PLANNING AND COMMUNITY DEVELOPMENT
CRAIG DOSSEY, EXECUTIVE DIRECTOR

December 21, 2017

Subject: VR-17-014 Review 1

AS PLATTED

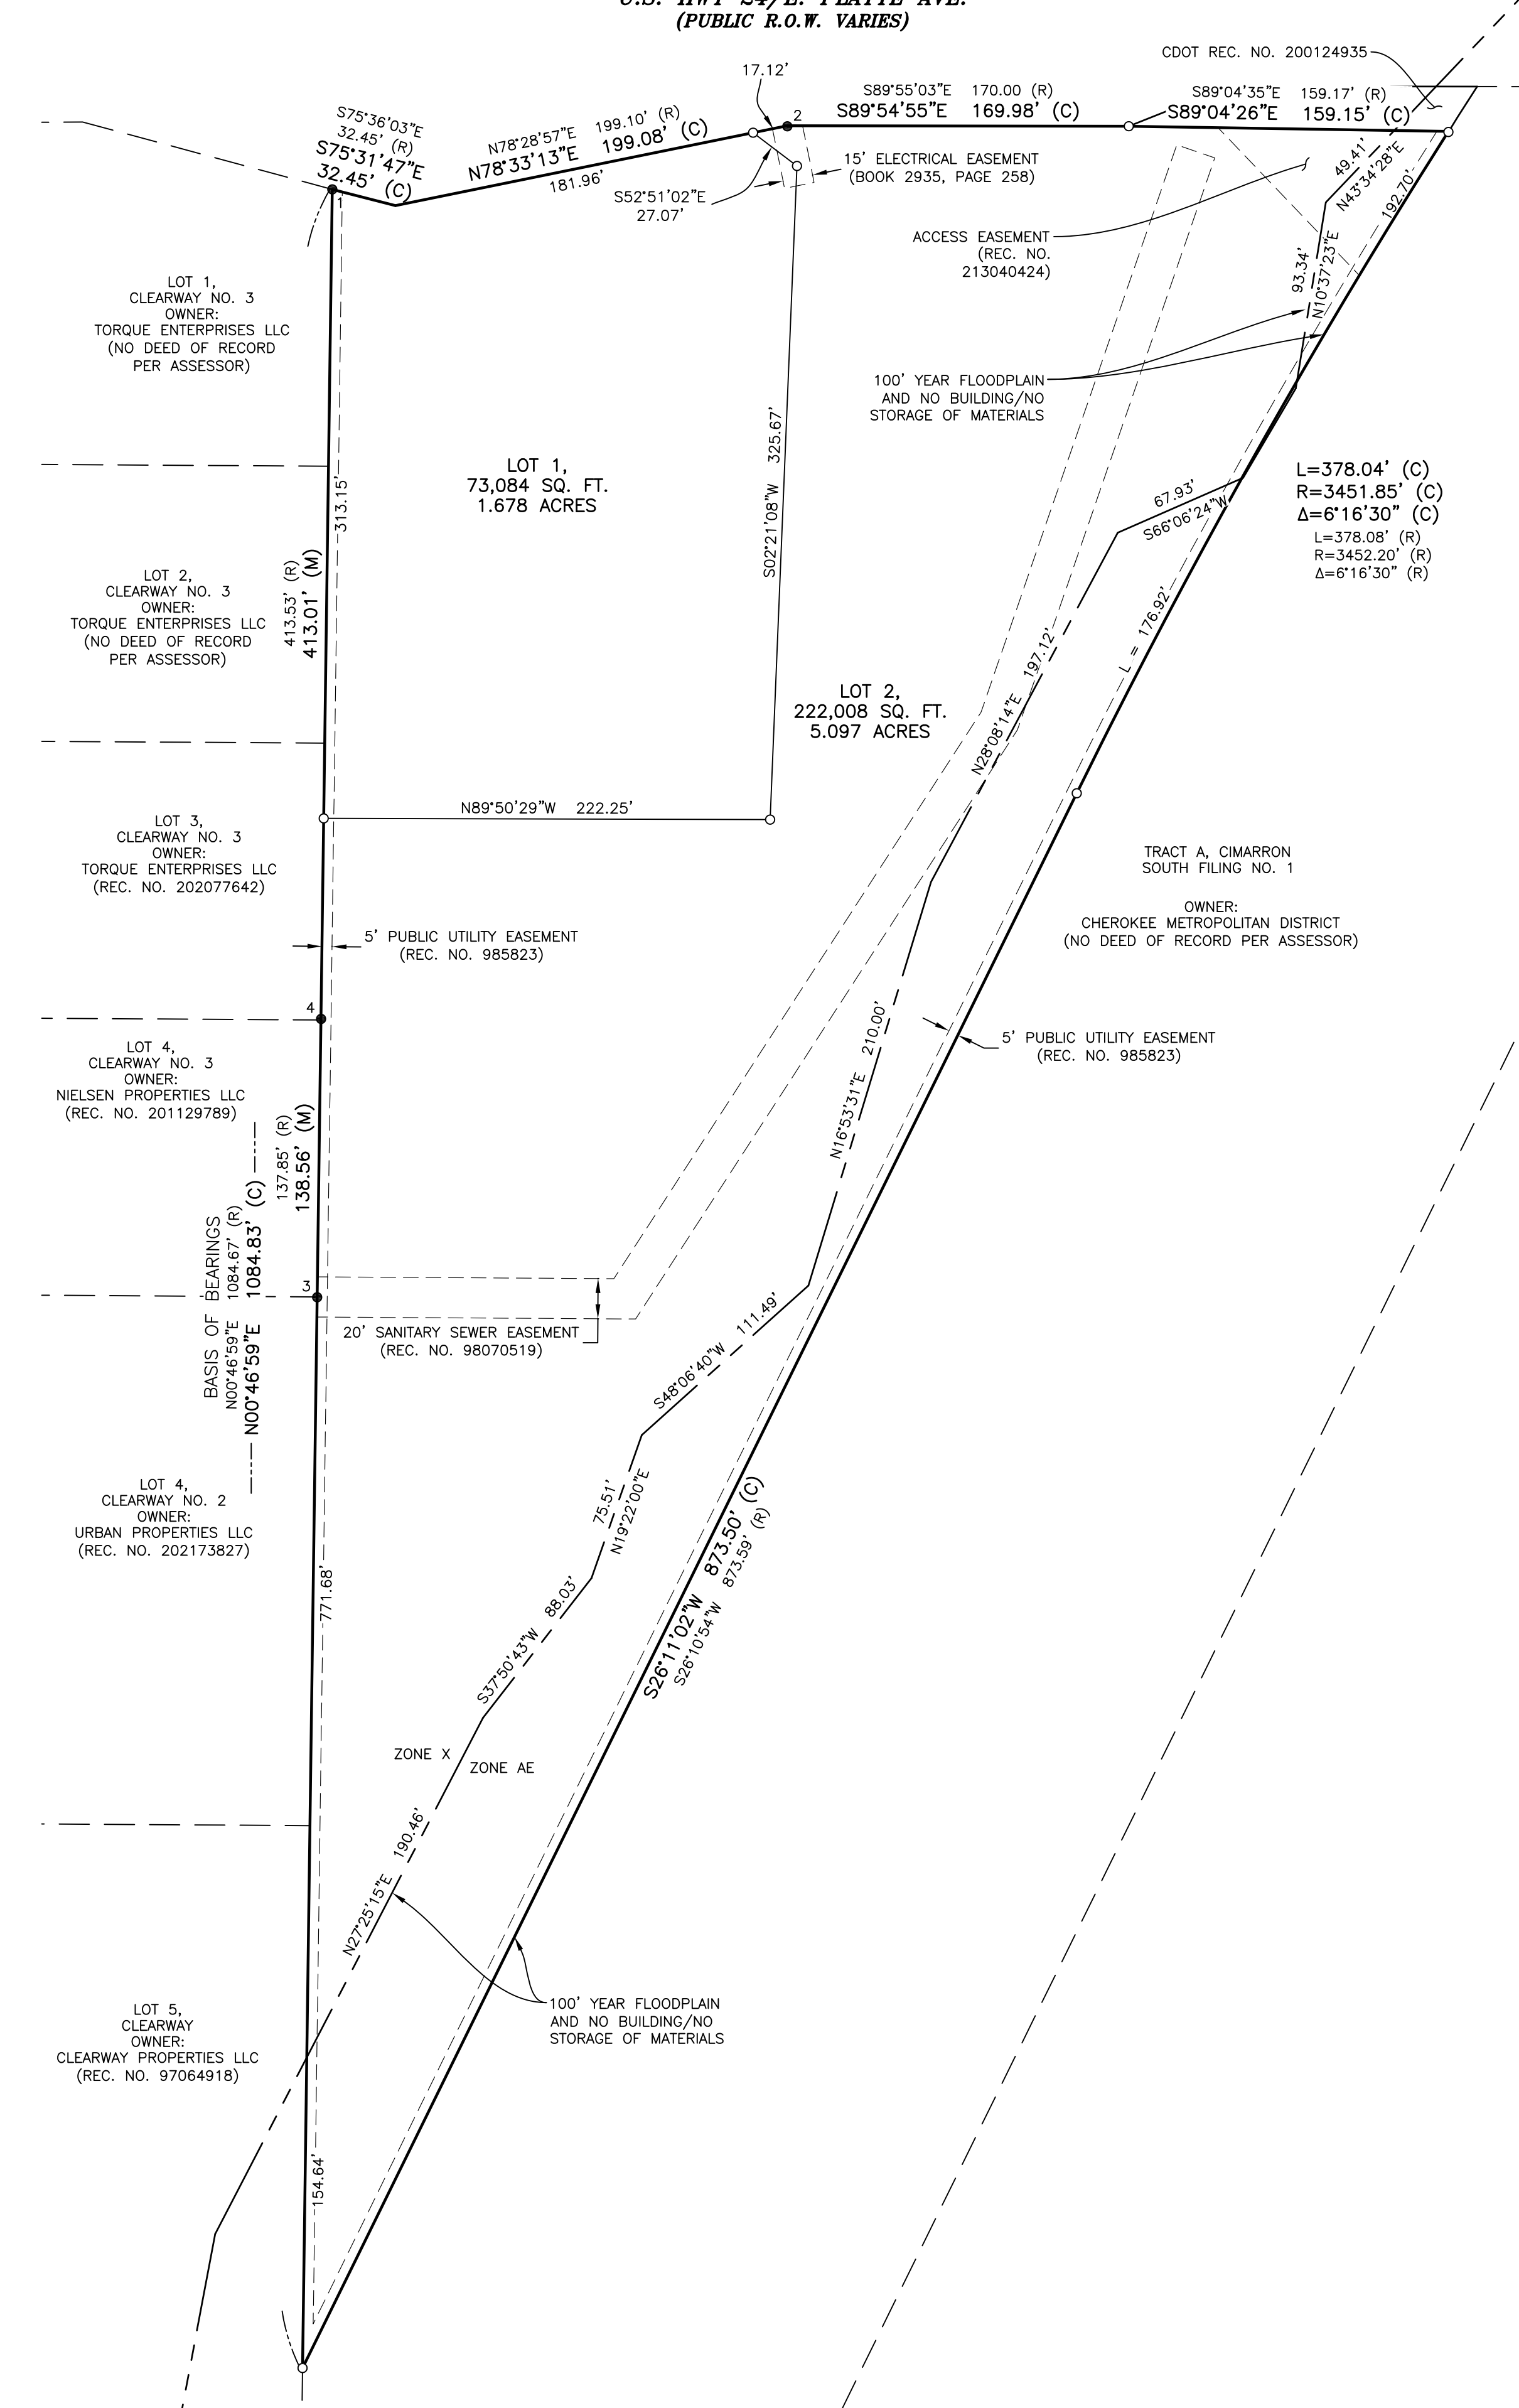
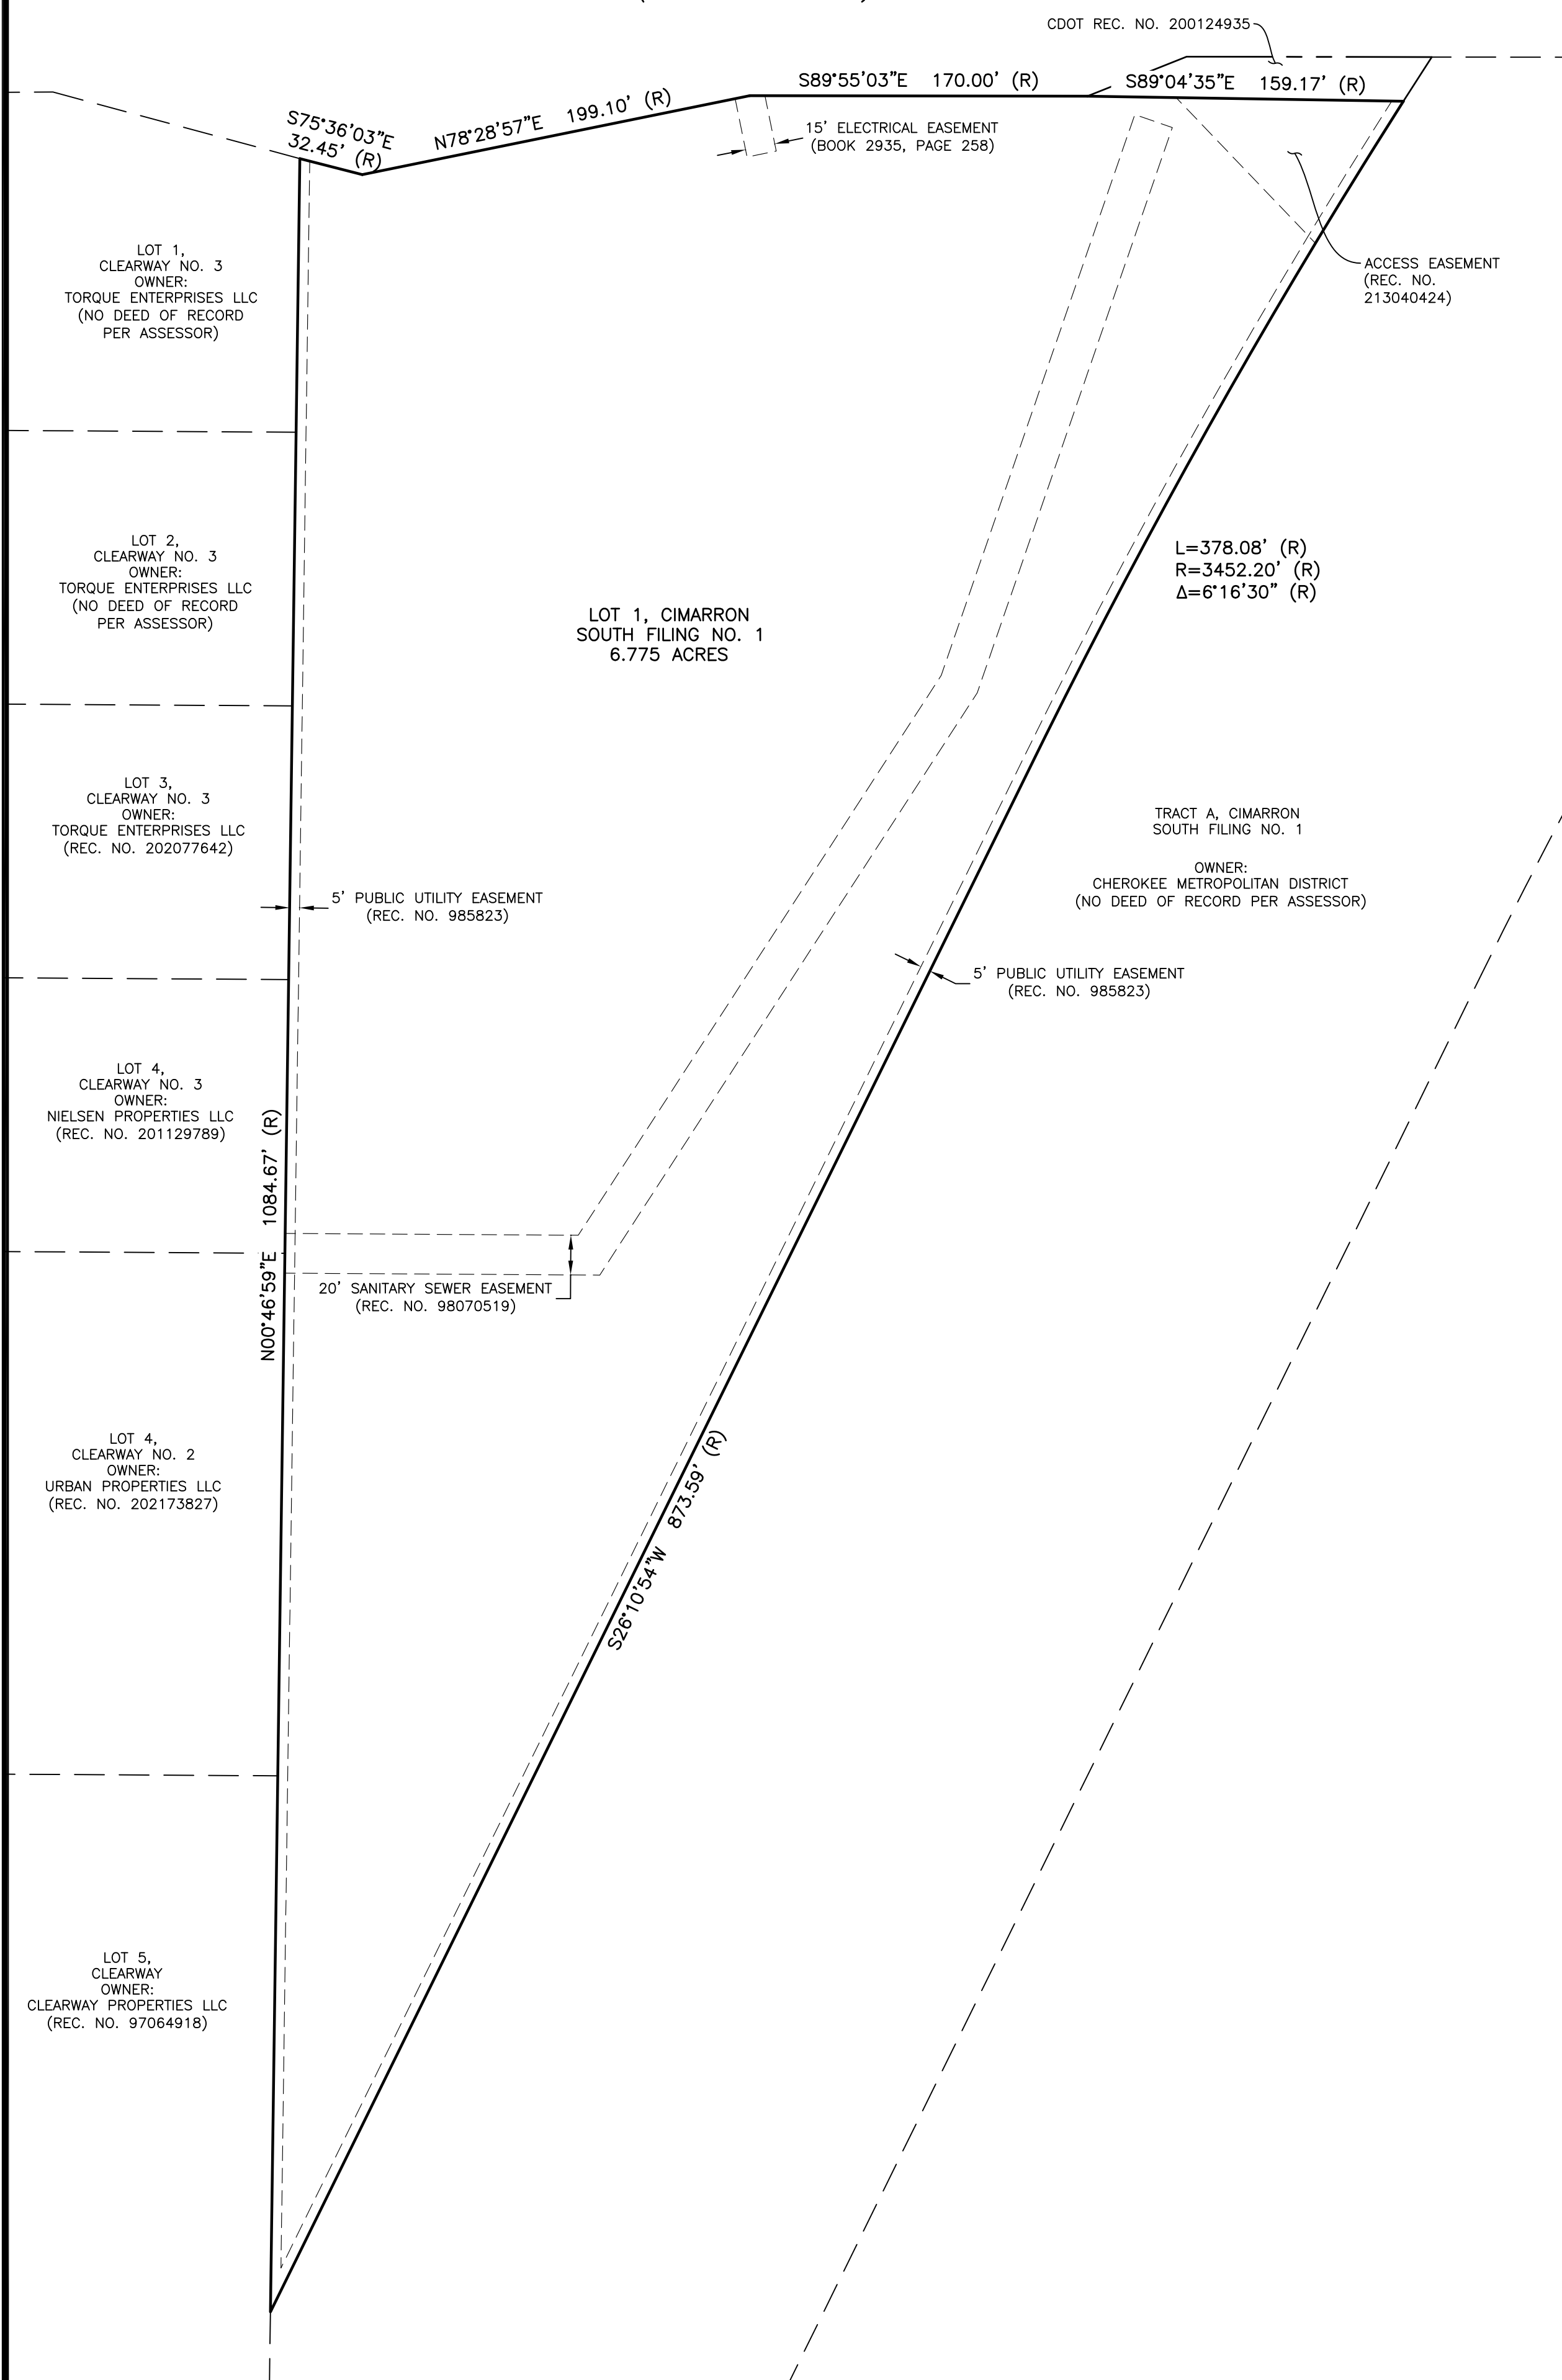
2. Please show and label on both the "As Platted" and "As Replatted" the existing electrical easement recorded at Book 2935, Page 258.
3. Please show and label on both the "As Platted" and "As Replatted" the existing easement recorded at reception number 213040424.

4. On the "As Replatted" please show that the 5ft side-lot easements were created by previous plat.
5. Please ensure that all electric transmission infrastructure is located in R.O.W., otherwise easements will need to be created.

Comments have been included in the revised submittal.
